DATE: September 8, 2023
FILE NUMBER: MAPN-23-0002 – Karman Line Land Use Plan
RE: Master Plan – 3rd Review
Colorado Springs Utilities
(Mike Gackle, 719-668-8262, mgackle@csu.org)
(Bryan English, 719-668-8119, benglish@csu.org)

KARMAN LINE LAND USE PLAN	SHEET	SHEET
COVER SHEET	CV	1
		OF 13

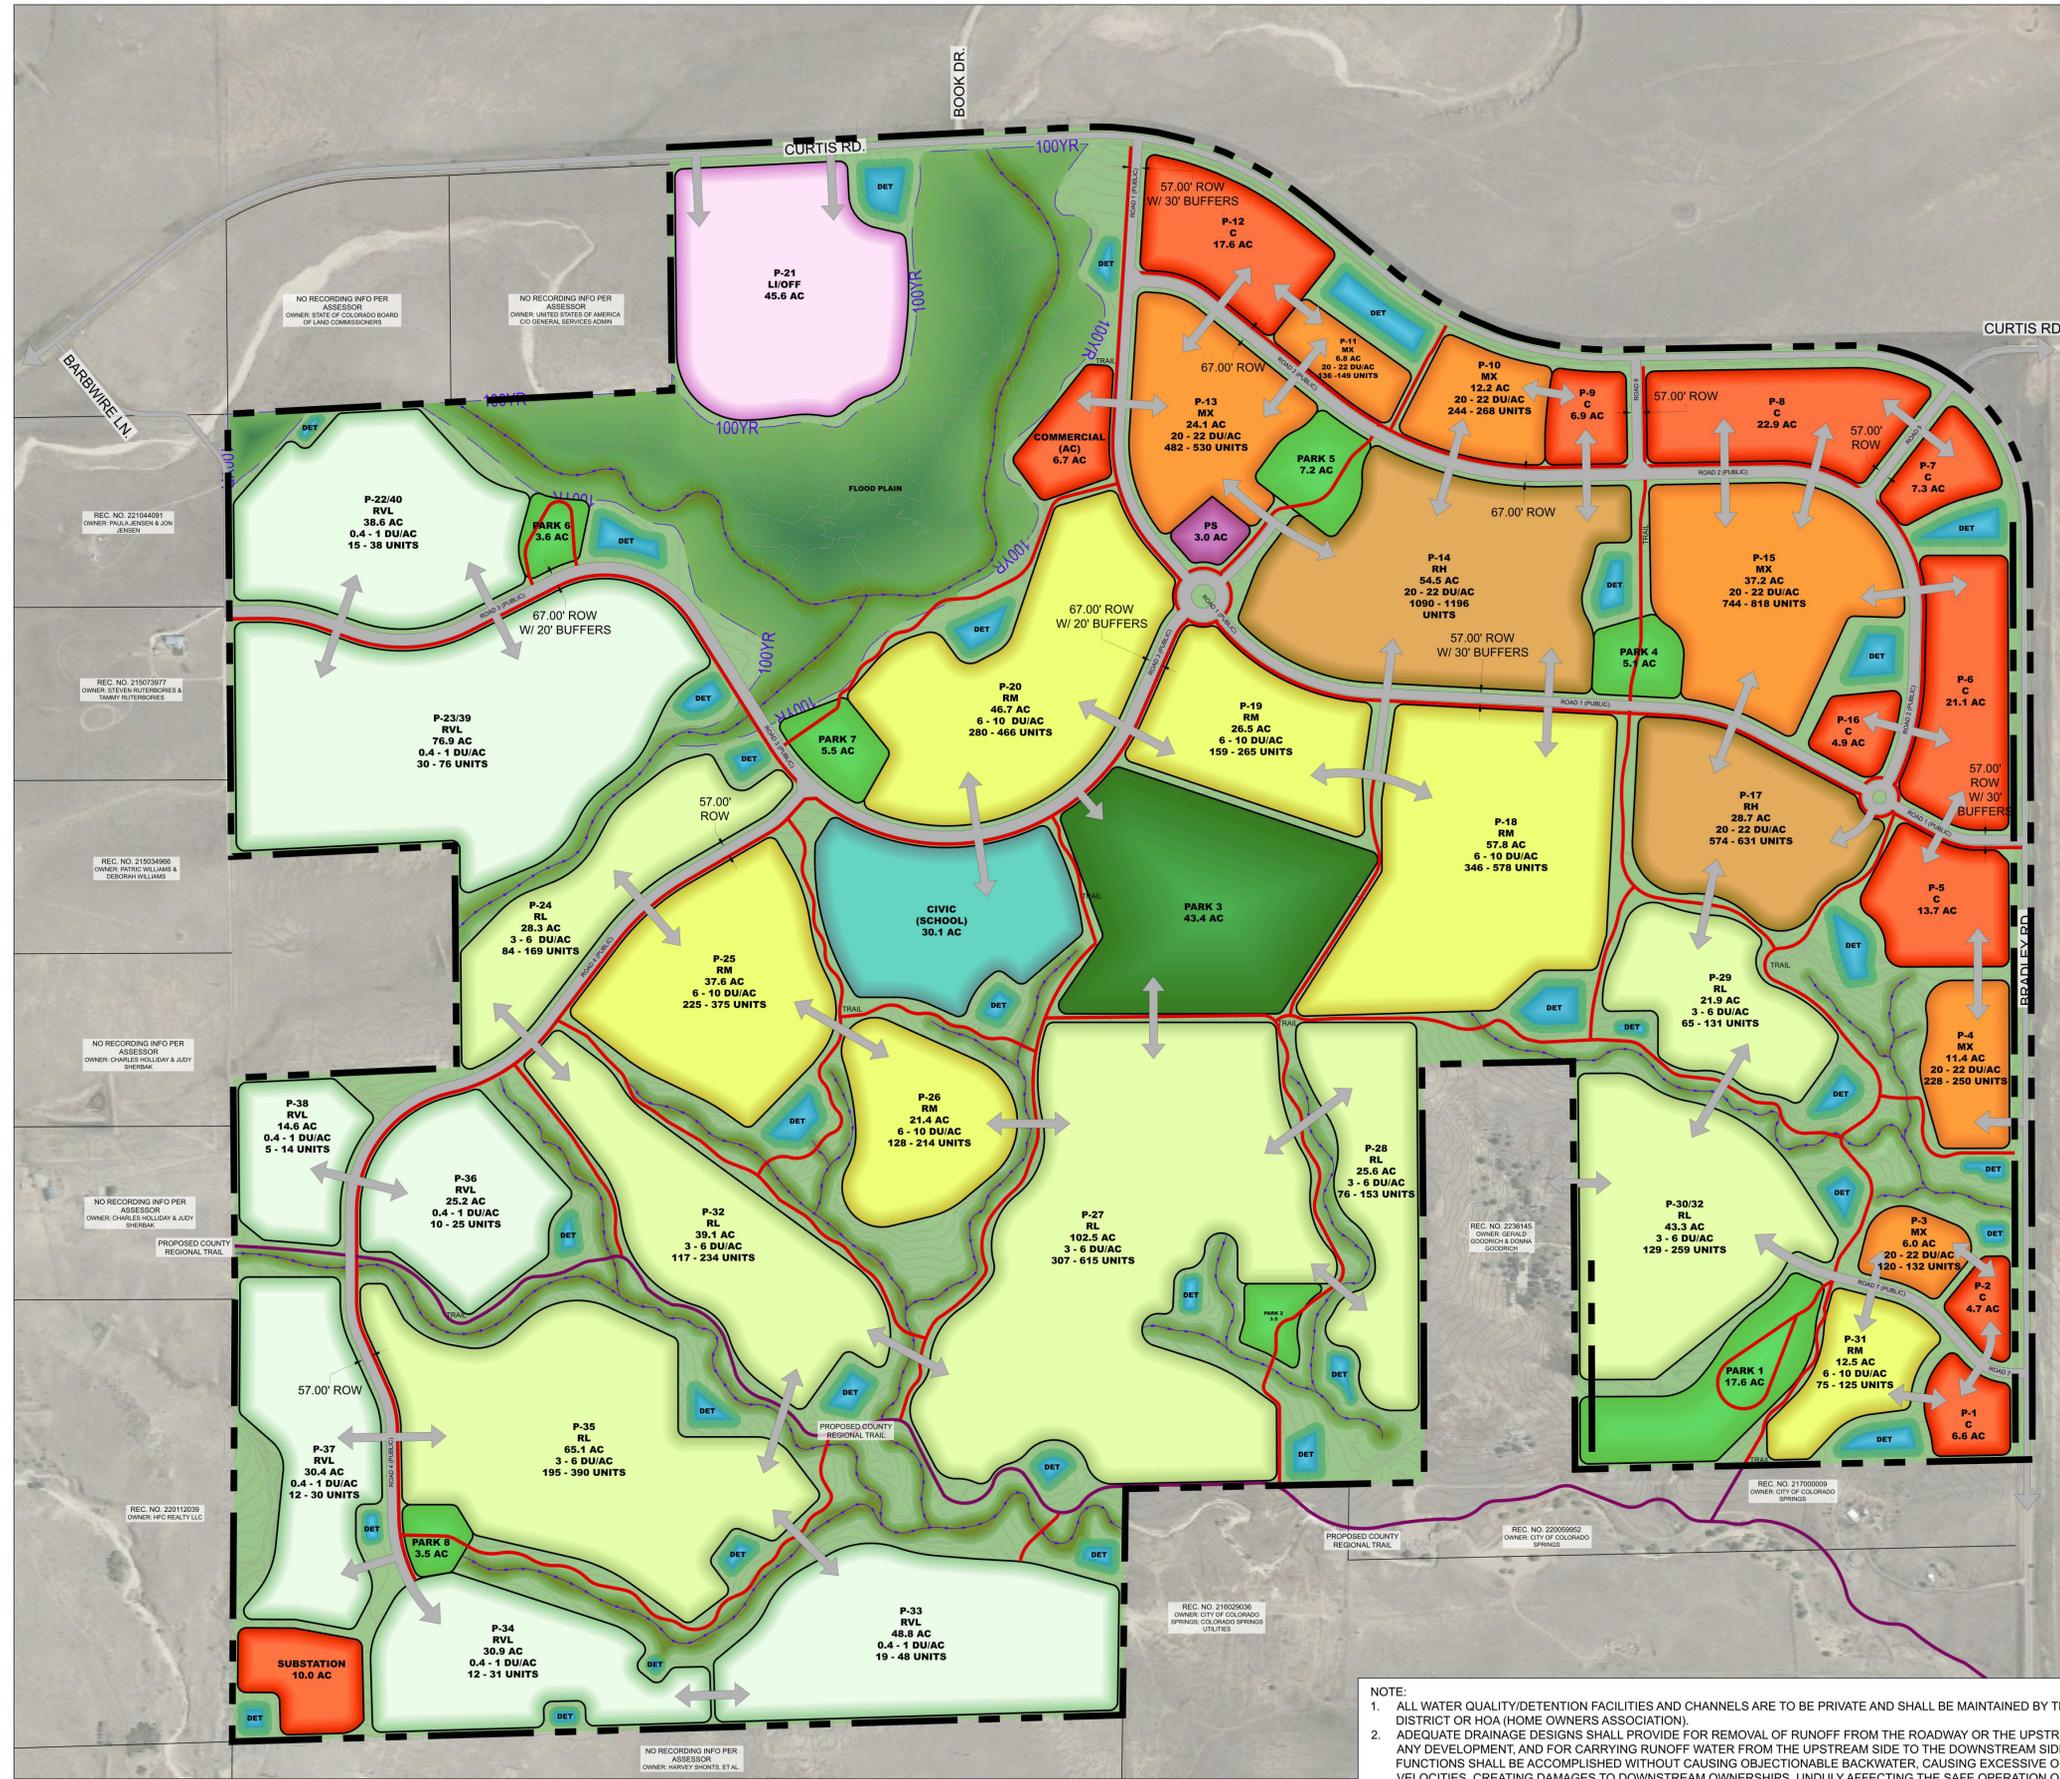
- Item addressed. Phasing plan appears to be consistent with prior information provided.
 - Phase 1 area in southwest corner of property appears to adequately align with planned facilities and minimizes immediate water main construction and water quality concerns.

- Phase 1 area in northwest corner of property (P-21, Light Industrial/Office) presents significant water quality concerns and further evaluation would be required.

Item addressed. Proposed substation site in northwest corner of property is generally acceptable. Significant mainline extensions from substation to initial development areas may be required and may increase developer-required cost contributions (i.e. Revenue Guarantee Contract) depending on phasing. Please refer to [Utilities Rules and Regulations](#) for more information concerning Revenue Guarantee Contracts.
